**App no: 24.0711**

**Address: Crow Trees Farm Crow Trees Brow Chatburn**

**Proposal: Approval of details reserved by conditions 5 (Estate Road Details), 6 (Estate Road Management), 8 (Off-site highway works) and 9 (Construction Management Plan) on planning permission 3/2022/0966.**

Client: Pringle Homes
Project: Crow Trees Farm, Chatburn
Drawing Title: Foul and Surface Water Drainage Plan

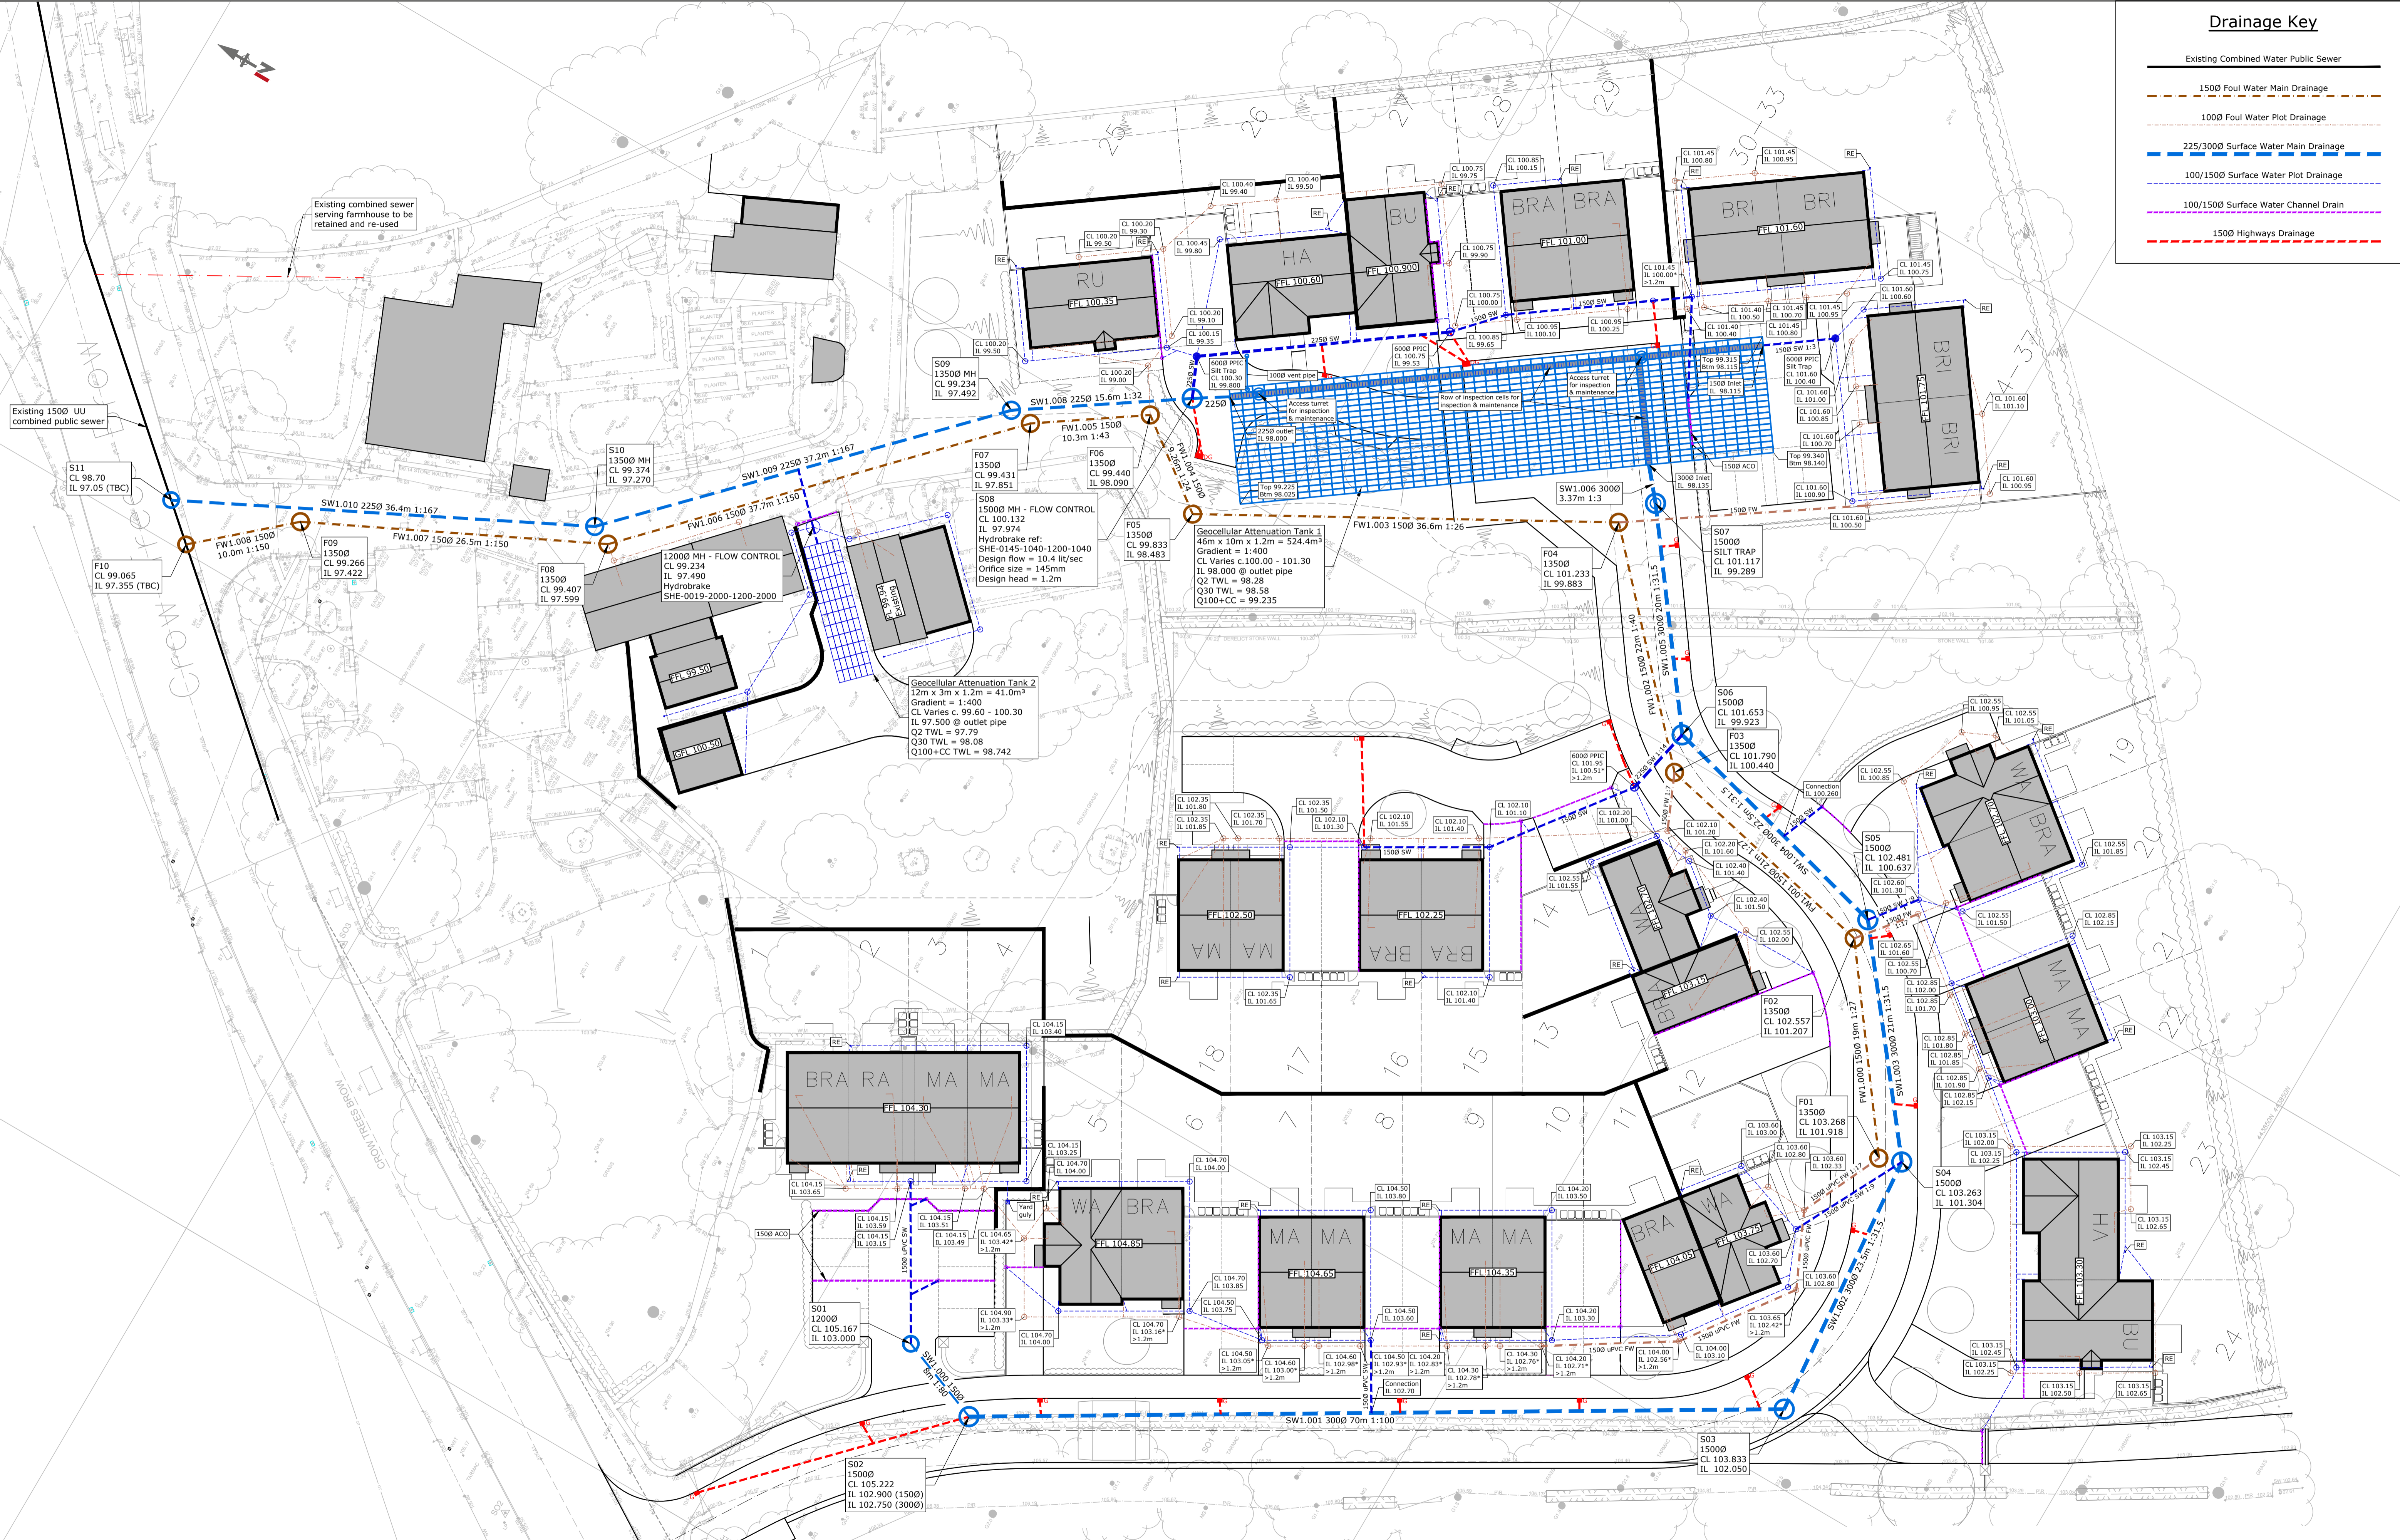
Currently with the drainage crates being sited under the estate road we would not consider the estate road for adoption and if the developer changed their mind then the drainage layout would need to be amended so that the crates are relocated from beneath the estate road.

Client: Pringle Homes	Scale @ A1: 1:250	First Issue: 19/03/24	Office of Origin: Kendal
Project: Crow Trees Farm, Chatburn	Drawn by: JB	Checked by: TM	Approved: TM
Drawing Title: Section 278 General Arrangement Plan & Details	Project No: K39346	Drawing No: 05	Rev: A
BIM No:

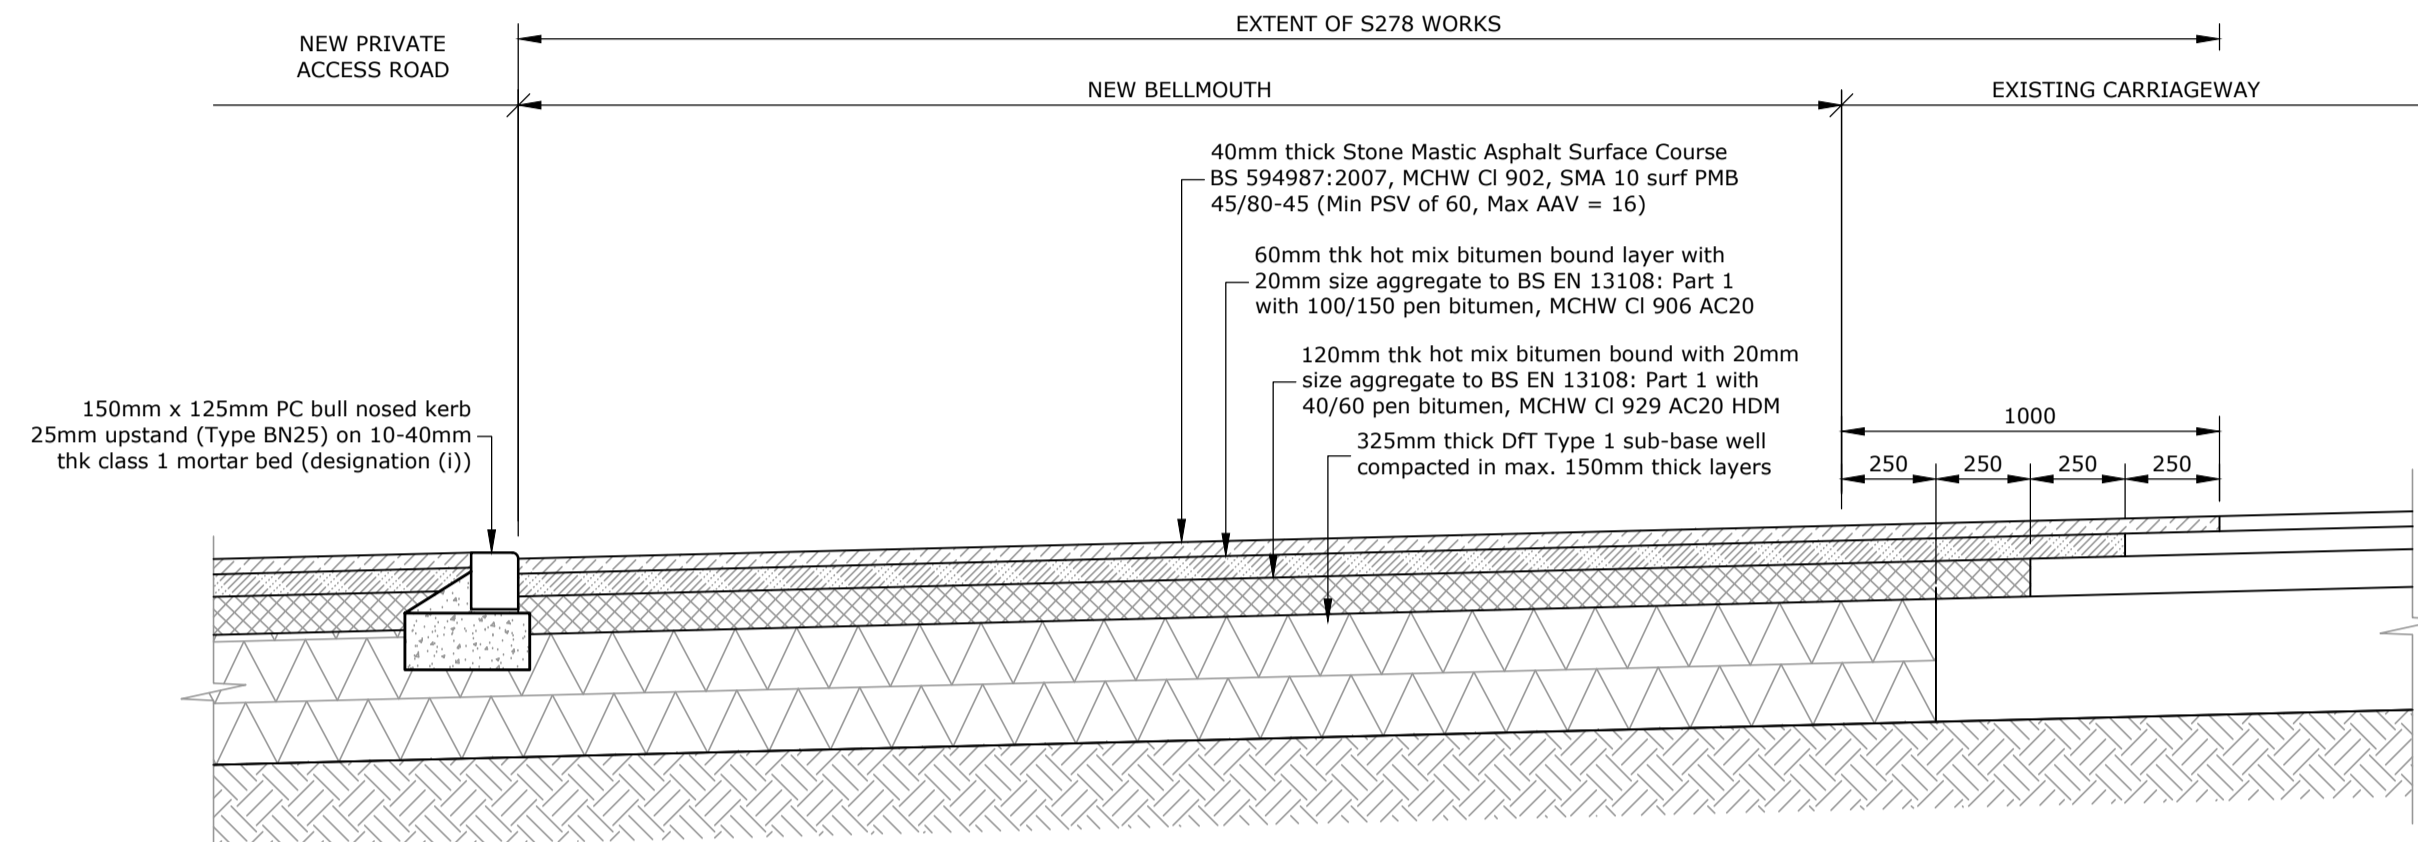
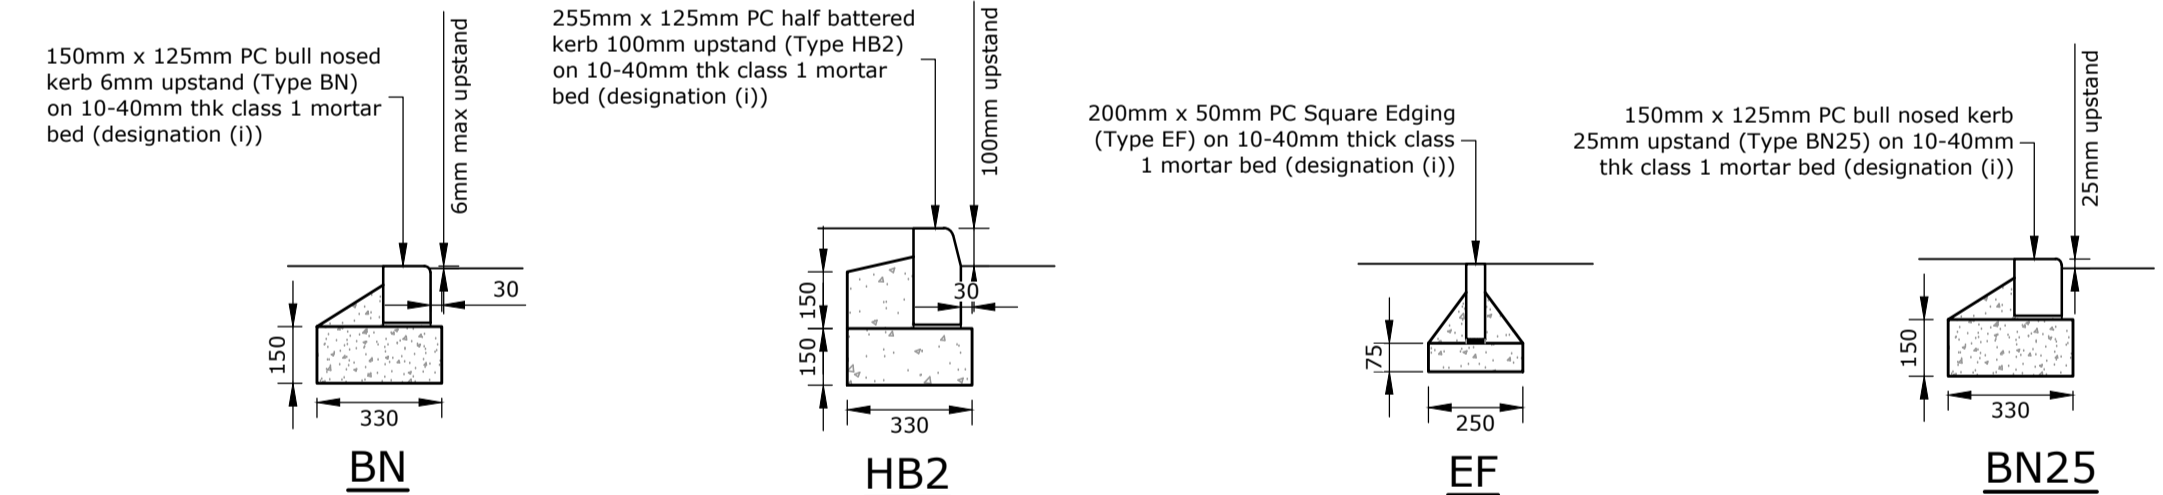
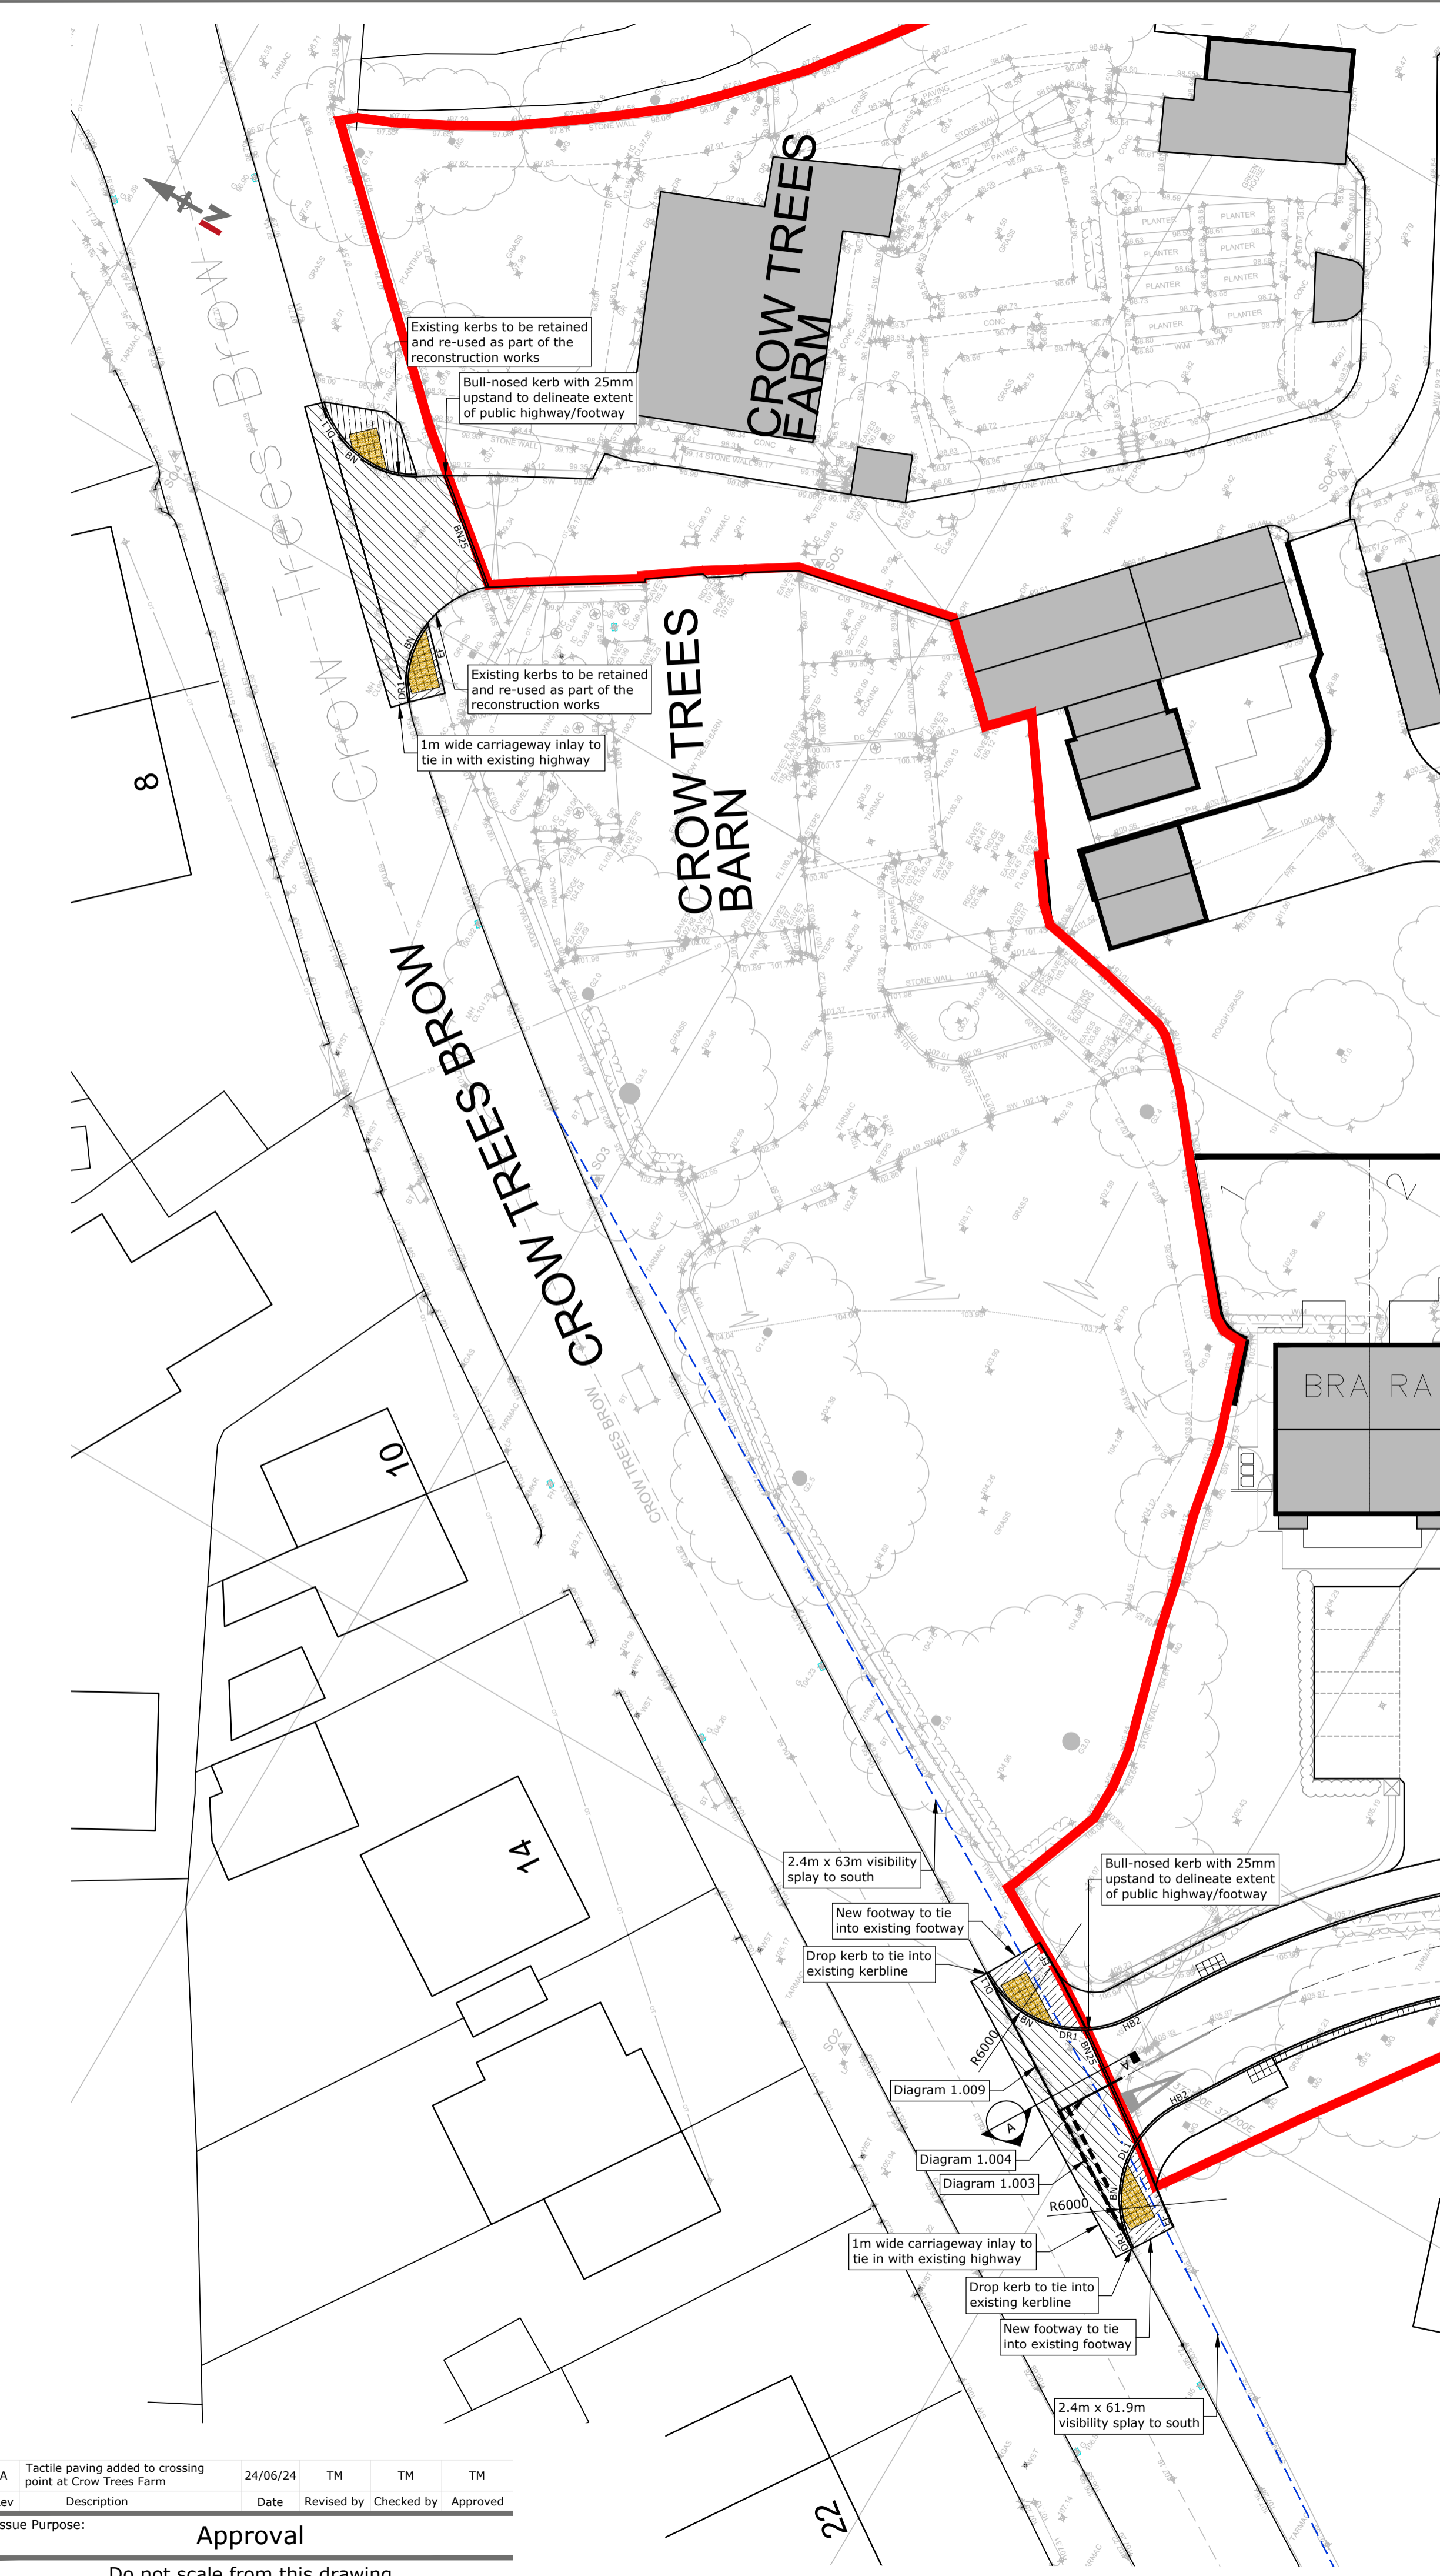
There is no objection to the discharge of this condition based upon the scheme submitted. The developer is required to enter into a S278 agreement before any works can be undertaken on the highway. We may request technical detail changes as part of the process and a more recent signage drawing has been agreed with the 'Pendle Witch' symbol added. The works should be completed before first occupation.
